Householder Proforma

2022/0394

24 Pilley Green Pilley Barnsley S75 3AE

Erection of double storey side extension designed to replicate existing architectural style including provision of front and rear facing dormer windows.

Proposed - Front Elevation - Scale 1:50

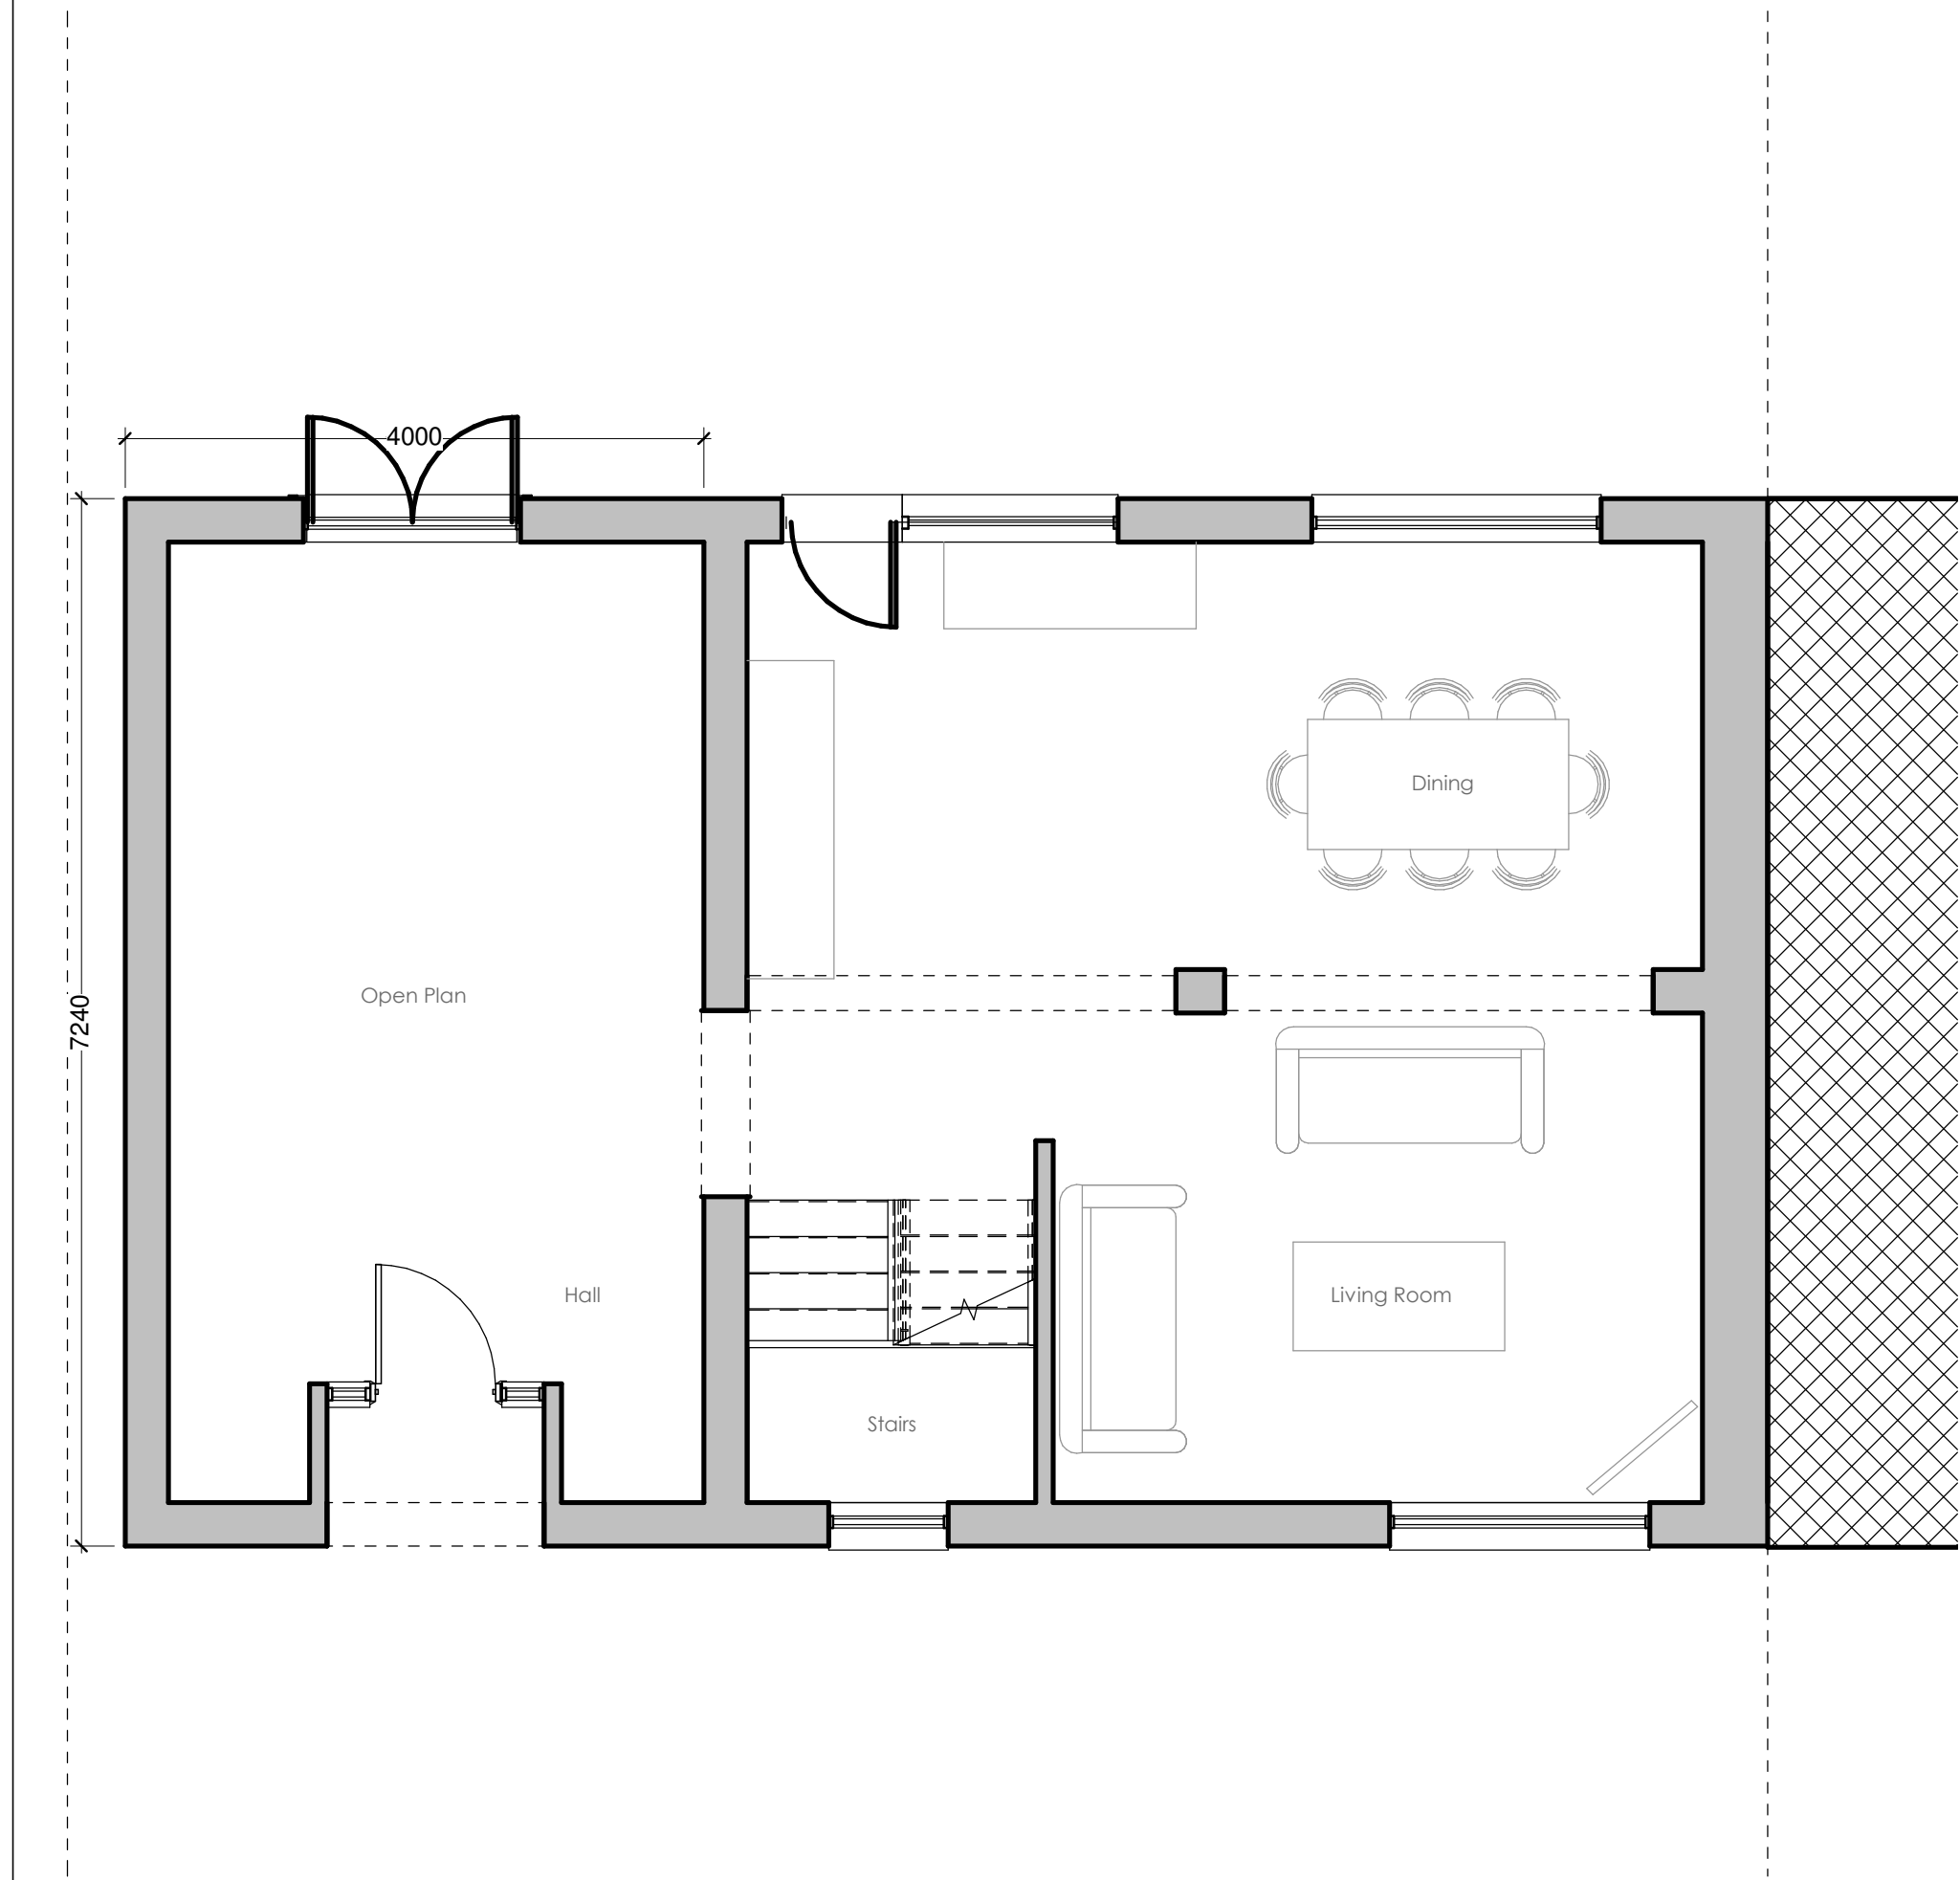
It is acknowledged that the side extension is not designed with a set back or corresponding lowering of the ridge line. However, the dwelling is located in a row of semi-detached properties of a mock Tudor design, and with front dormer windows set below the eaves. It is considered that the benefits of a setback would not outweigh the lack of inclusion, given that the front elevation has an abundance of features. It is therefore considered that a set-back would add to this and detract from the character of the original dwelling. Whilst no set-back is provided, the extension is designed with a sideways projection of less than 2/3 width of the original dwelling, maintaining the original dwelling as the dominant feature.

The extension is designed to harmonise with the original dwelling, with the windows having similar proportions to the existing. In addition, the proposed development sees the introduction of a door to the front elevation of the dwelling. As mentioned previously the dwelling is set back significantly from the highway and the existing boundary treatments along Pilley Green provide screening of the dwellings.
